**RE: Slim Chicken
8240 Montgomery Blvd NE
Grading and Drainage Plans
Engineer's Stamp Date: 04/26/21
Hydrology File: G19D004E**

Based upon the information provided in your resubmittal received 04/26/2022, the Grading & Drainage Plan is **not** approved for Building Permit and for action by the DRB on Site Plan for Building Permit. The following comments need to be addressed for approval of the above referenced project:

SLIM CHICKEN
8240 MONTGOMERY BLVD NE
GRADING AND DRAINAGE PLAN

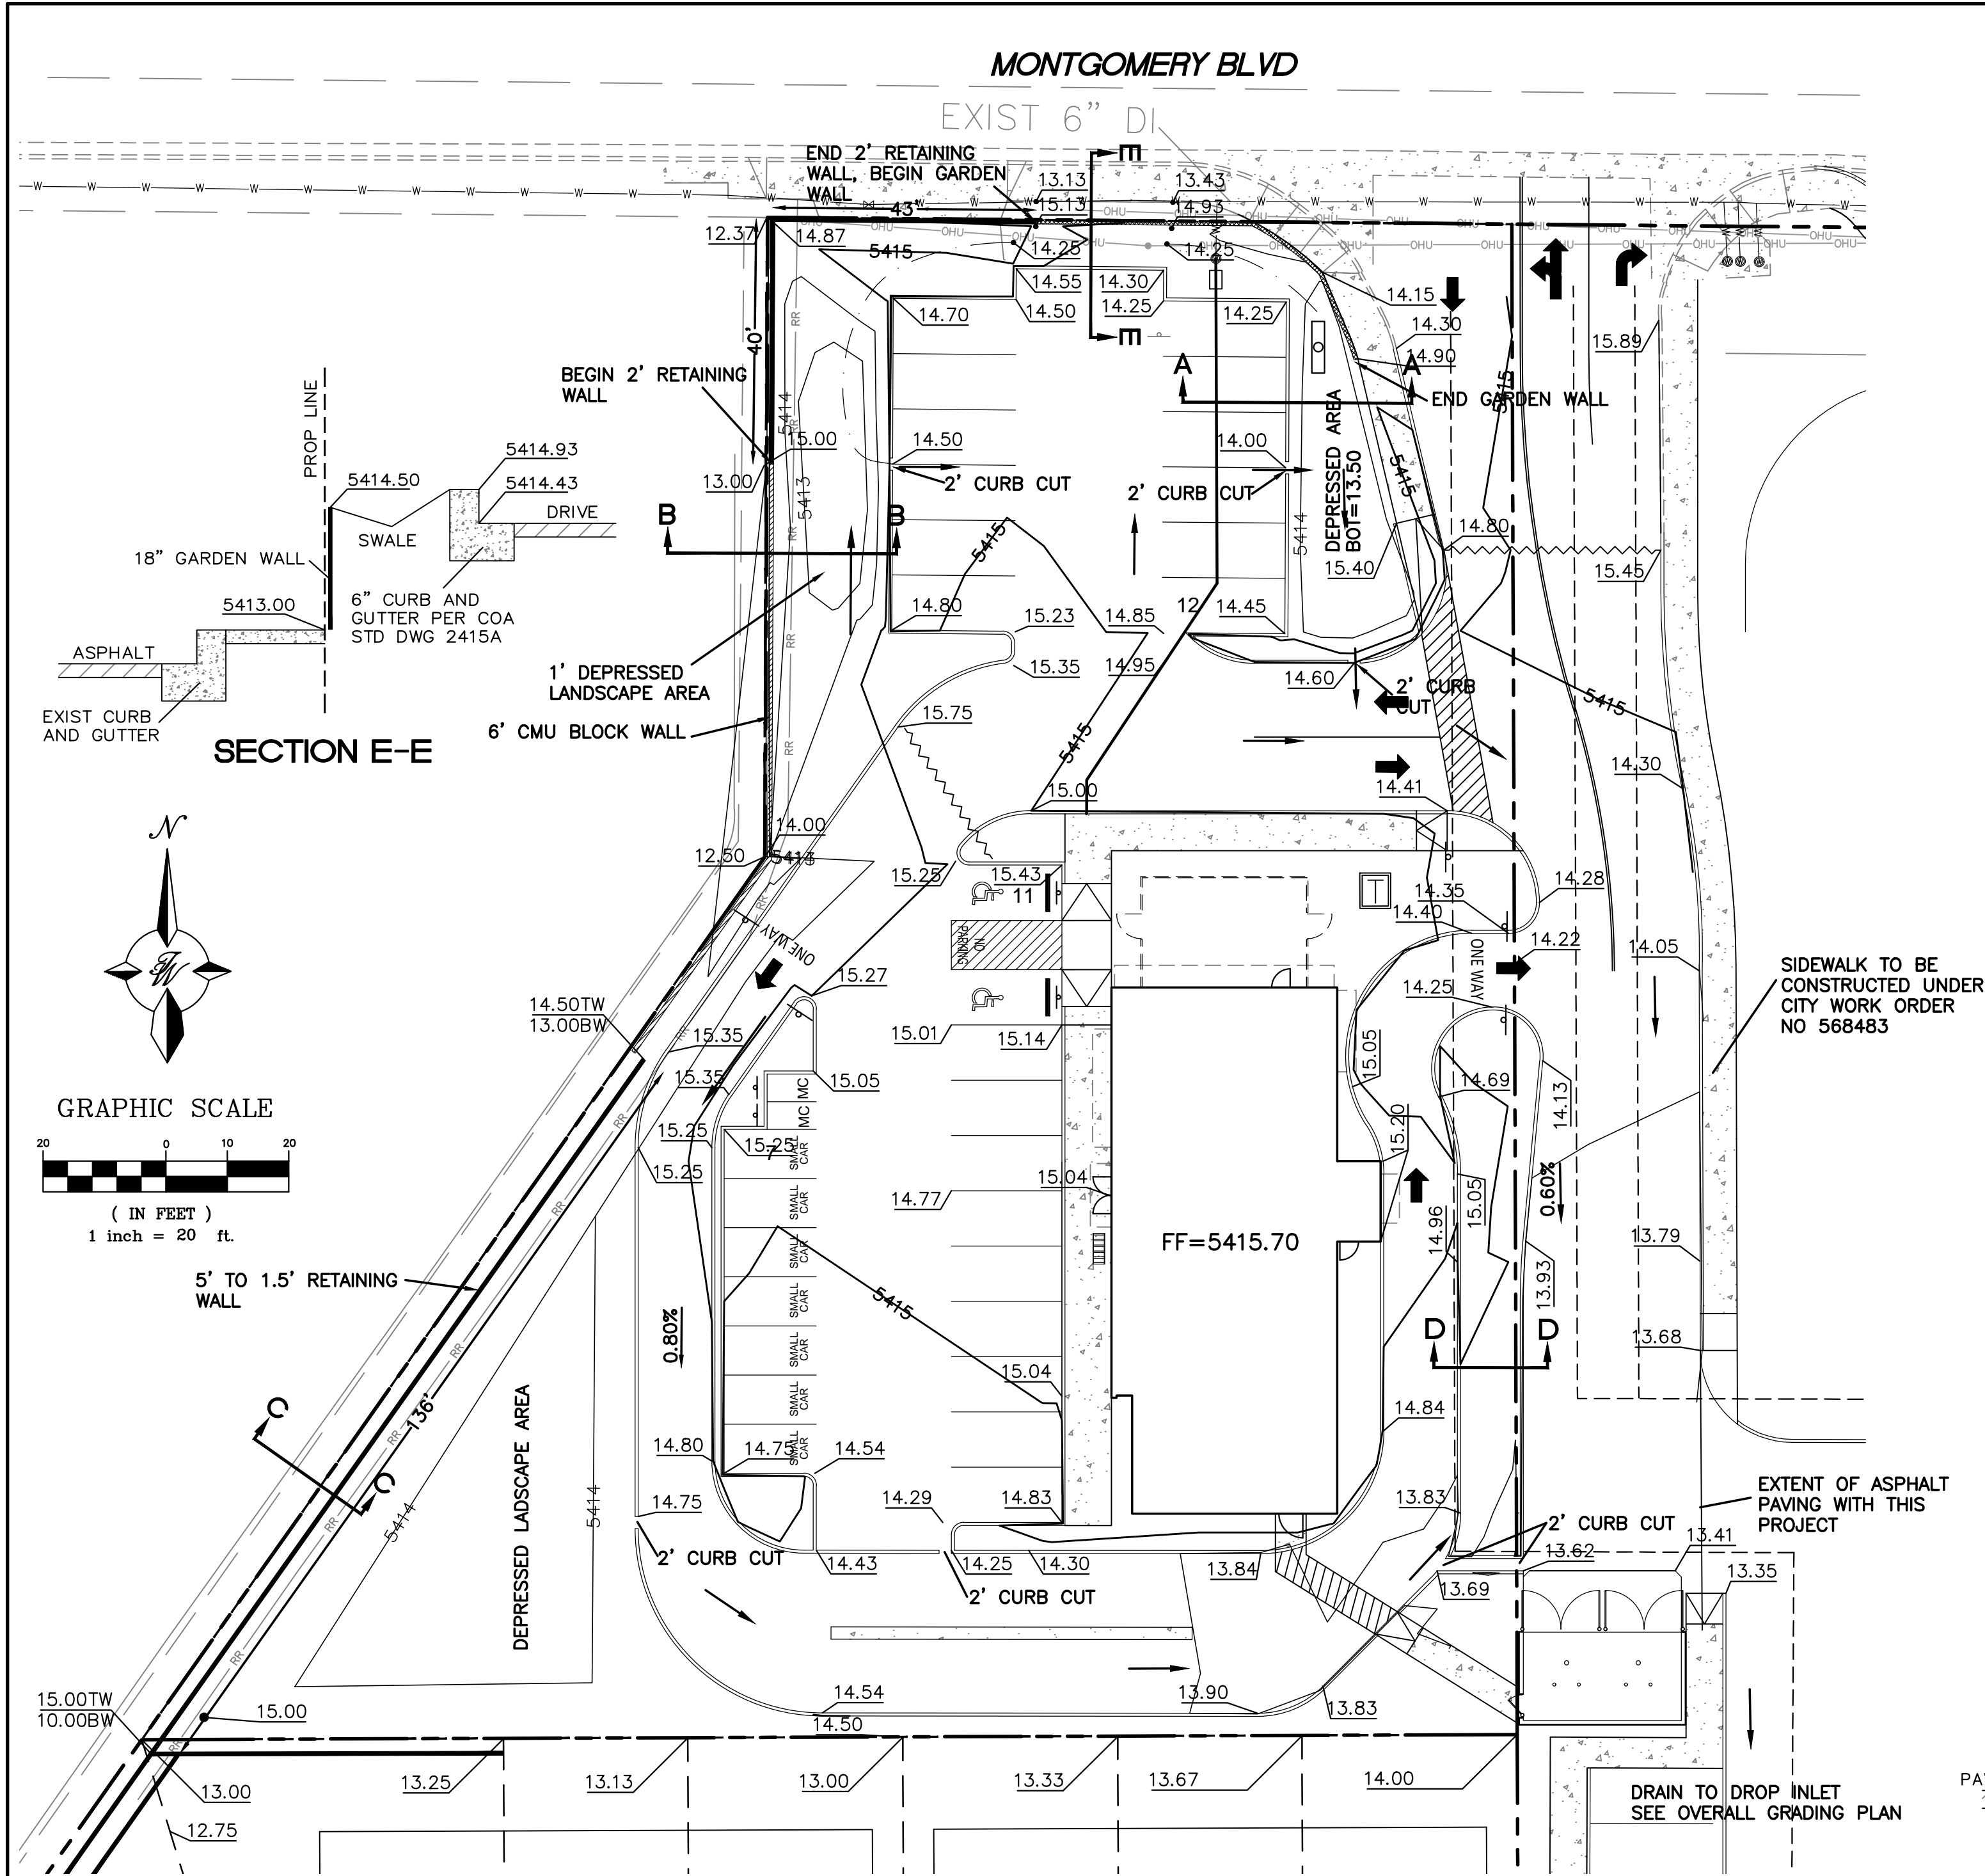
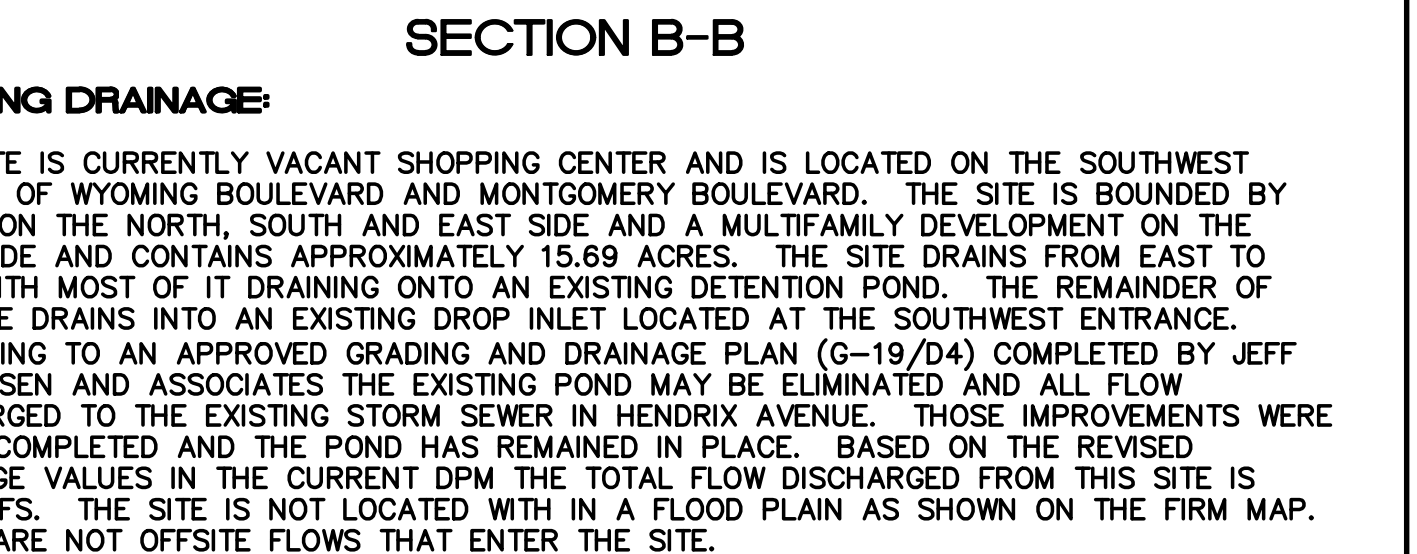
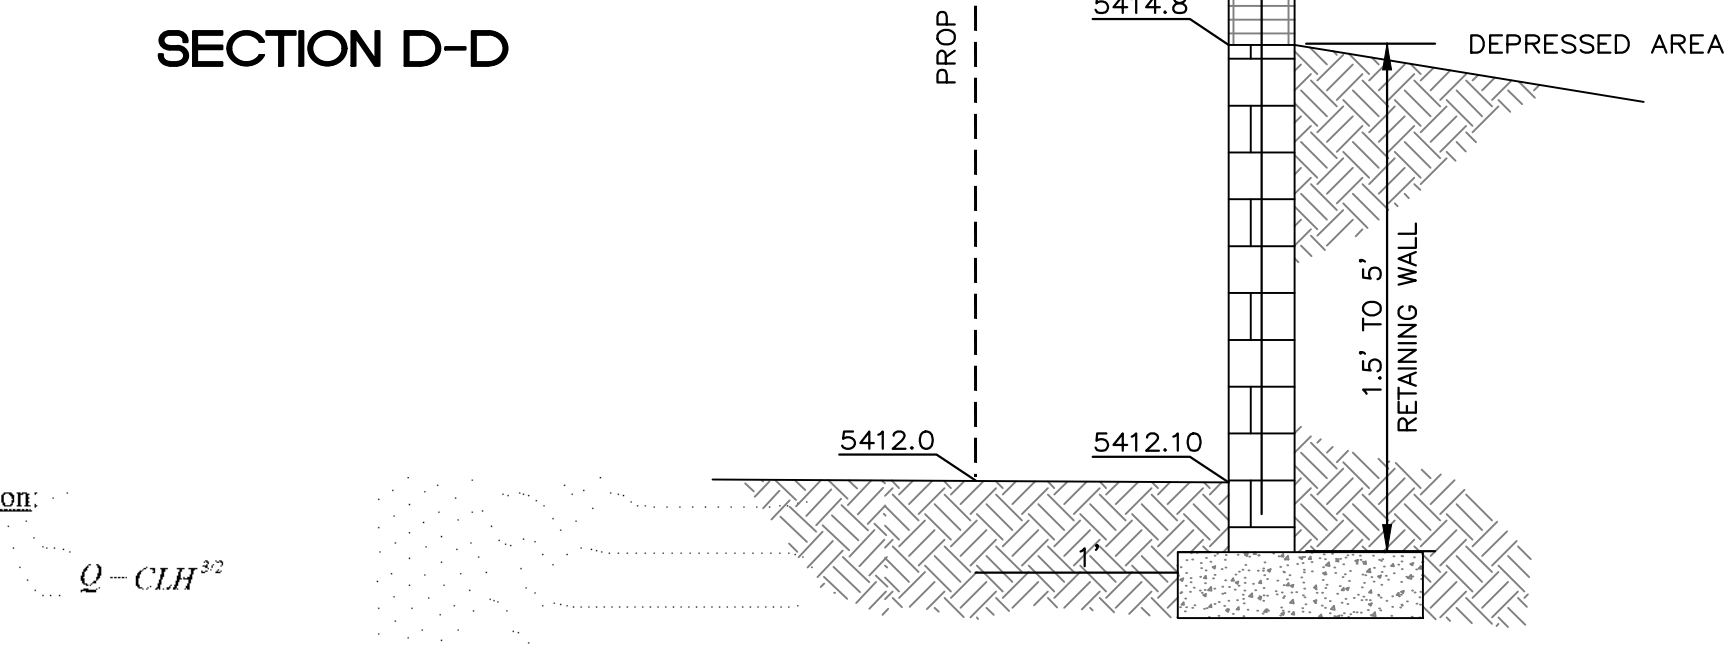
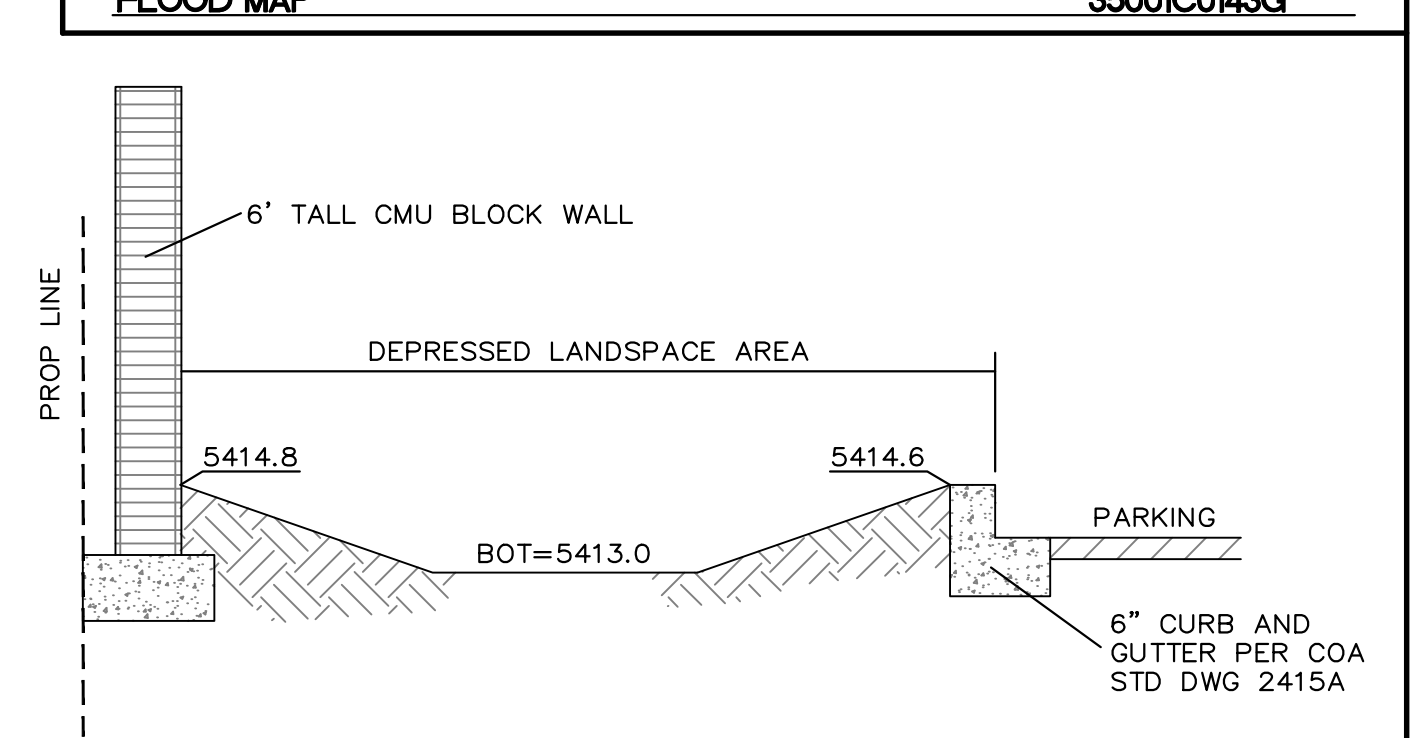
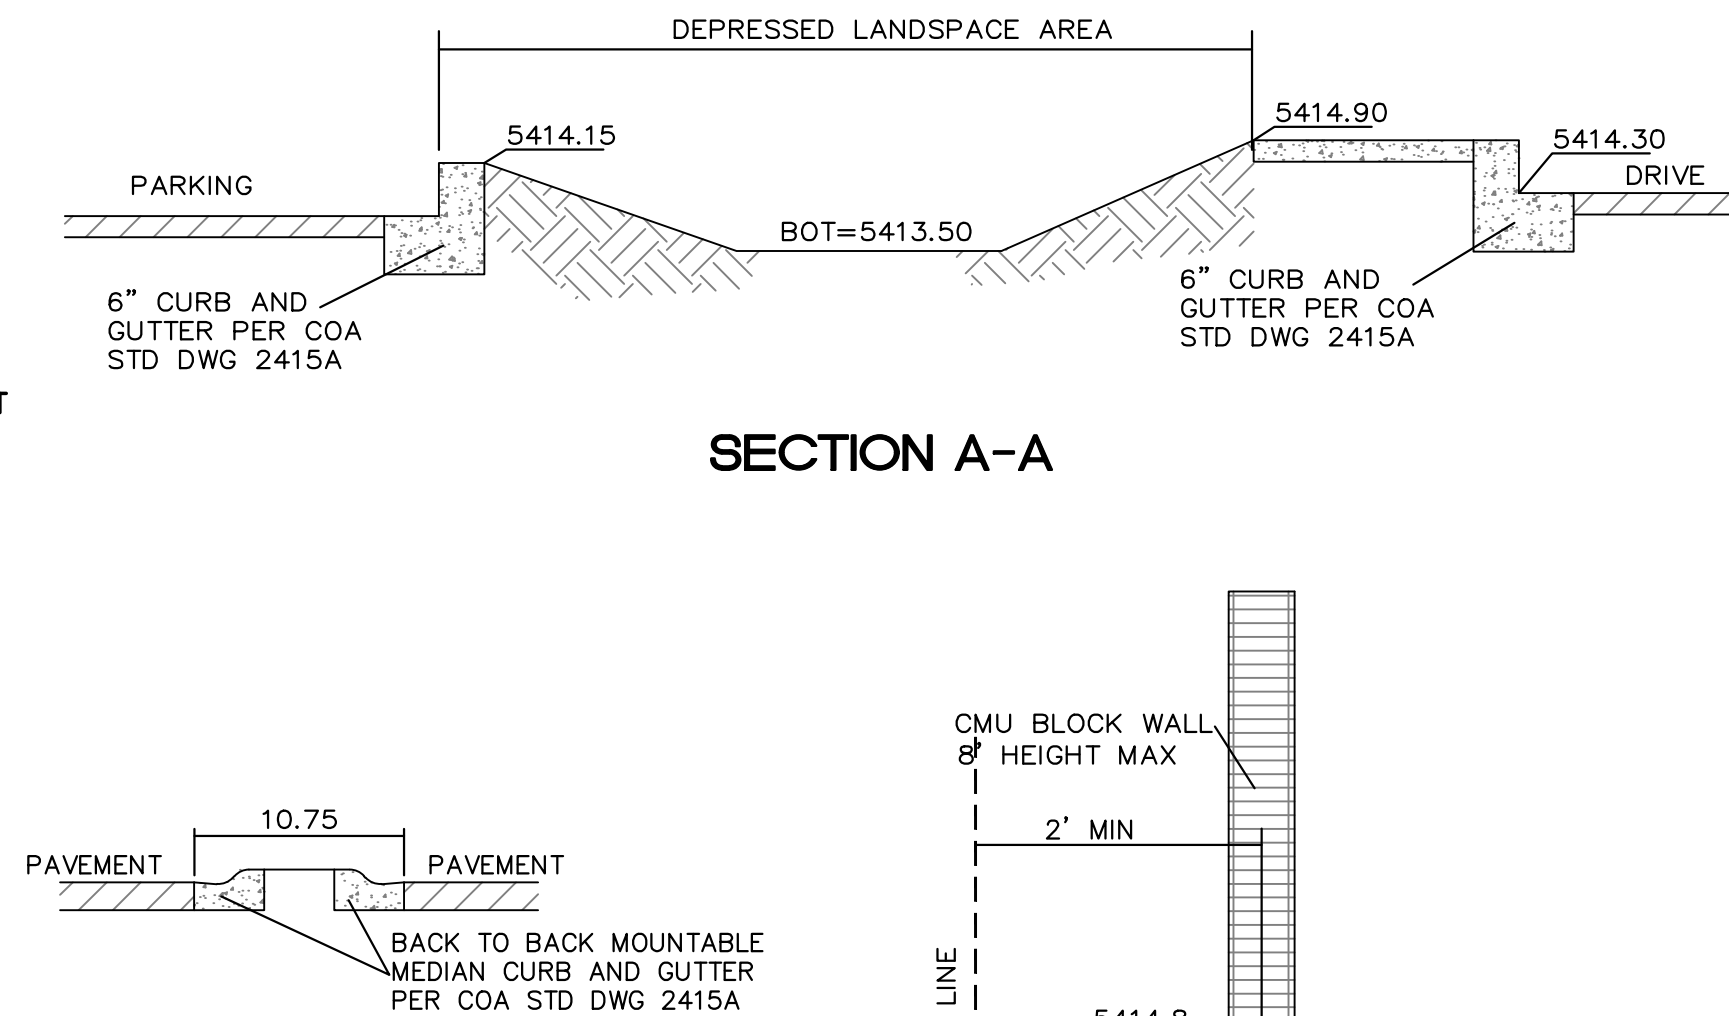
1. Please cleanup overlapping text.

2. The entire Tract A needs to follow the approved overall development drainage management plan. See the wording below from that plan.

COMMERCIAL BASIN "A" AND "B" WILL DRAIN SOUTH TO A PROPOSED DROP INLET LOCATED JUST NORTH OF WYMONT CIRCLE. THOSE FLOWS WILL BE CONVEYED THROUGH STORM SEWER TO THE WATER QUALITY POND. BASIN "C" WILL DISCHARGE TO A PROPOSED DROP INLET AT THE ENTRANCE ON MONTGOMERY AND DRAIN VIA STORM SEWER TO THE DROP INLET THAT CAPTURES BASINS "A" & "B".
